**From:** Anita Gardner  
**Sent:** 26 July 2018 15:39  
**To:** Planning.Responses  
**Subject:** FW: LU/191/18/DOC

**om:** Colin Giddings  
**Sent:** 25 July 2018 14:03  
**To:** Anita Gardner  
**Subject:** LU/191/18/DOC

**Condition 5 –CMP**

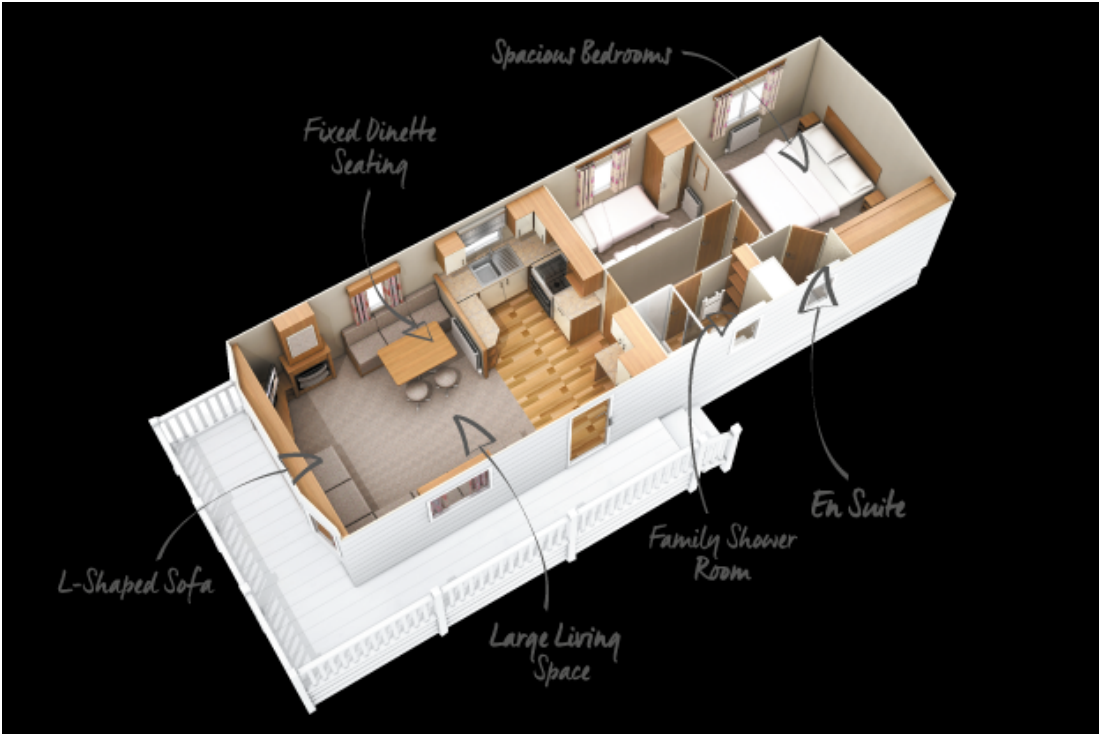
**Condition 8 – Cycle Store**

There is mention of a plan for the proposed wooden structure but I have not had sight of this. The site will need to comply with spacing and safety standards when in operation. Without details of the proposed structure I cannot comment further.

There has been full drawings of the wooden shed, this particular one is sprayed FireChief to give fire resistance.
